From: Amanda Scholes on behalf of Planning.Responses
Sent: 09 November 2017 08:59
To: Planning Scanning
Subject: FW: BE/102/17/OUT

Consultation response from Environmental Officer

From: Fiona Fitzgerald
Sent: 08 November 2017 14:19
To: Planning.Responses
Cc: Michael Eastham
Subject: BE/102/17/OUT

1 BLOCK PLAN - SHADOWS
1:1000

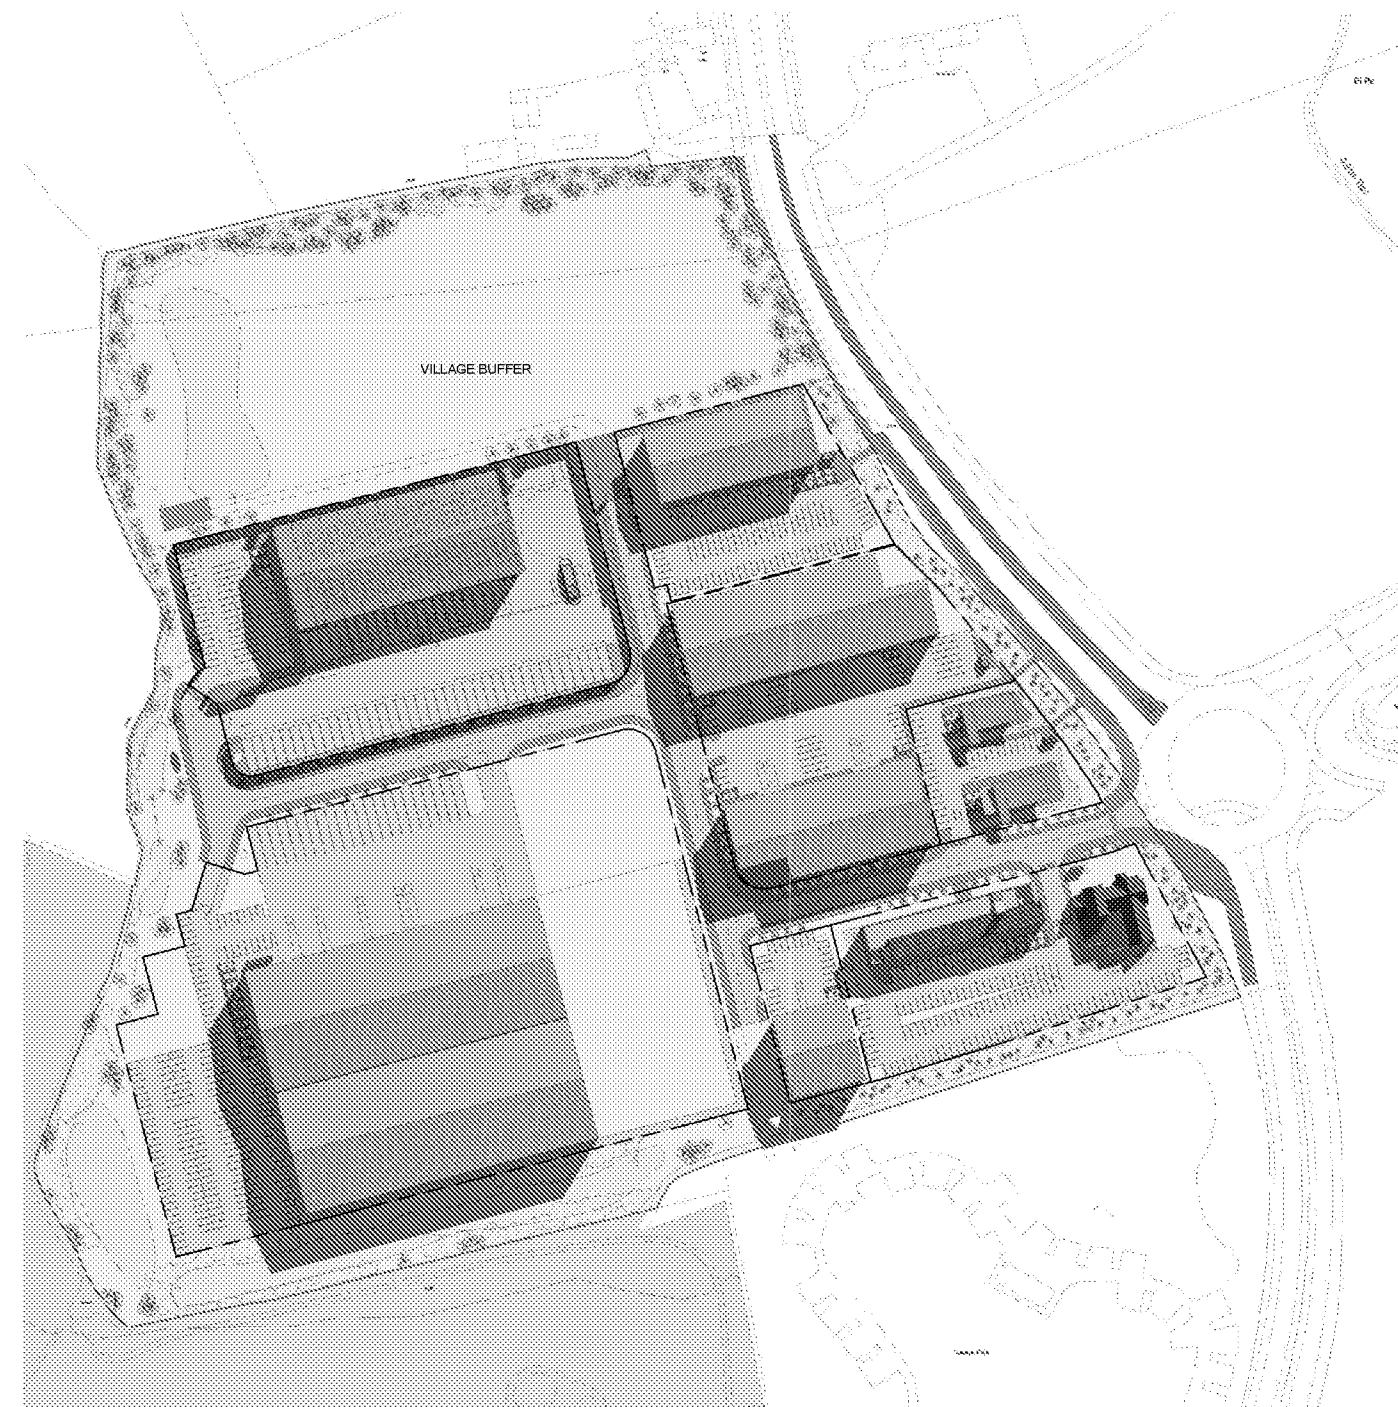
4. Paragraph 4.5 on page 12, just to clarify, "all loading bays" means all loading bays in unit two presumably?
5. Paragraph 4.15. Agreed.
6. Paragraph 4.21. This states that a level dock loading bays will be sited at the northern elevation. Does this mean loading to and from HGVs will take place facing north i.e facing the Shripney Road properties? If so paragraph 4.23 cannot be consistent with paragraph 4.21. If the loading bay is at the north by definition the doors will have to be opened and closed frequently for accurate access and egress of product so acoustic performance of the warehouse structure cannot rely on the doors being closed. However looking at the plans it appears that the loading docks will be on the southern elevation. Please could the applicant clarify?
